## PLANNING CONSULTATION RESPONSE

<b>Application No</b>	2026/0310
<b>Proposal</b>	Installation of a multifunctional communication Hub including defibrillator and advertisement display. (Planning Consent)
<b>Address</b>	Pavement outside 50 Cheapside, Barnsley
<b>Date of Consultation Reply</b>	18/05/26
<b>Consultee</b>	Highways DC

**SITE PLAN & IMAGES**

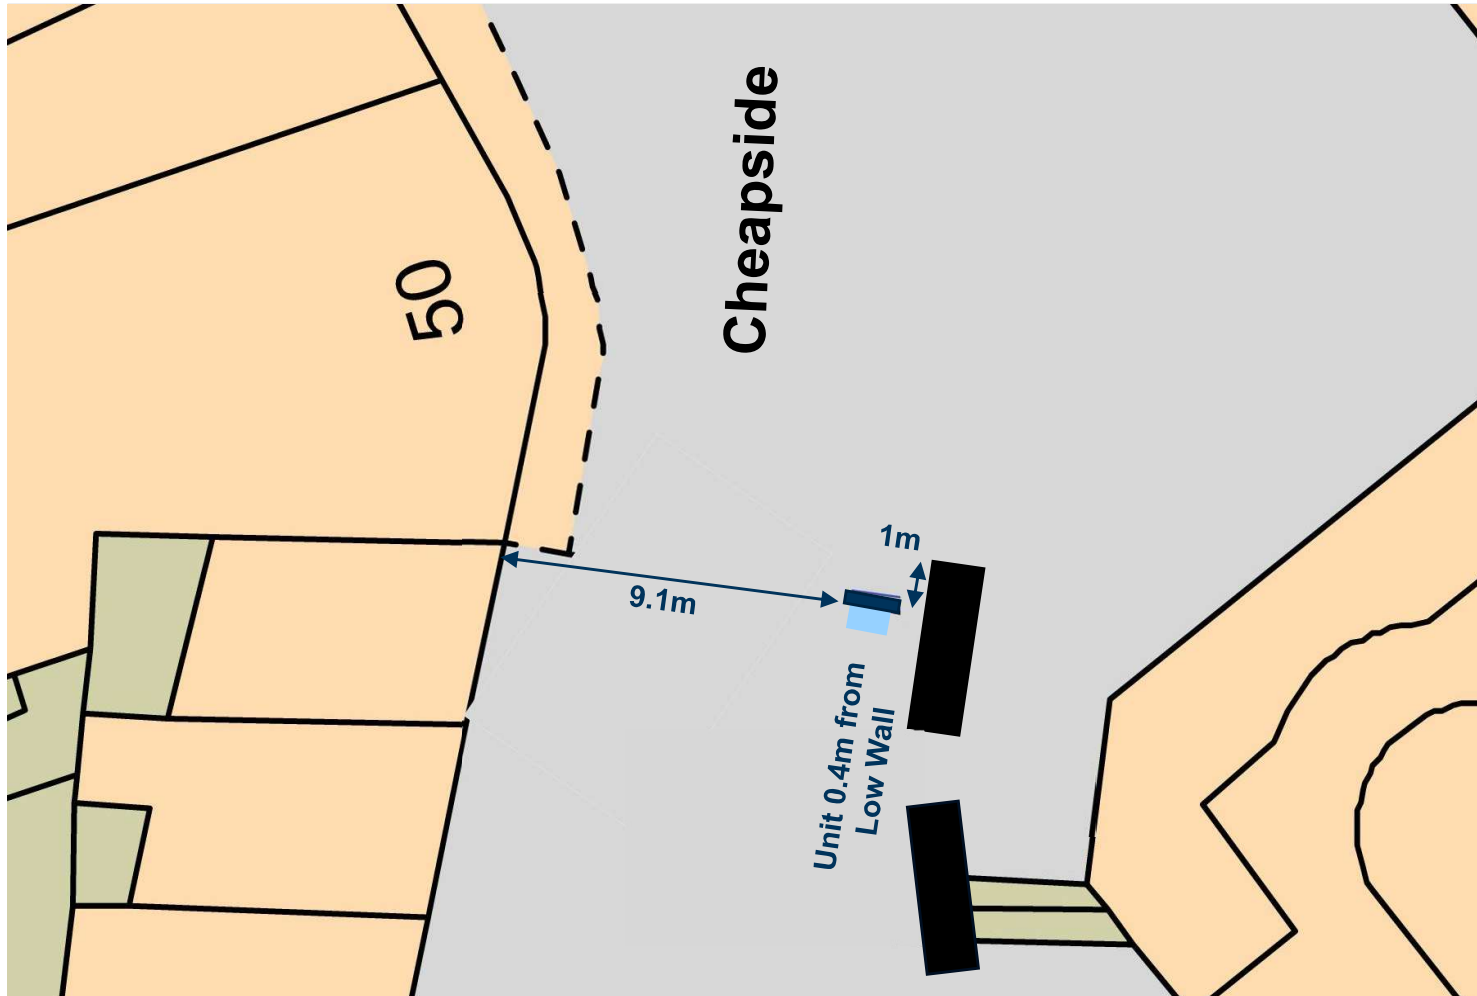
In this instance, the hub is set on what remains live carriageway and may therefore cause an obstruction to delivery vehicles during periods where loading and unloading is allowed.

As such, HDC would raise objection to the scheme on the grounds that the proposal increases unnecessary street clutter and would cause an obstruction on the public carriageway.
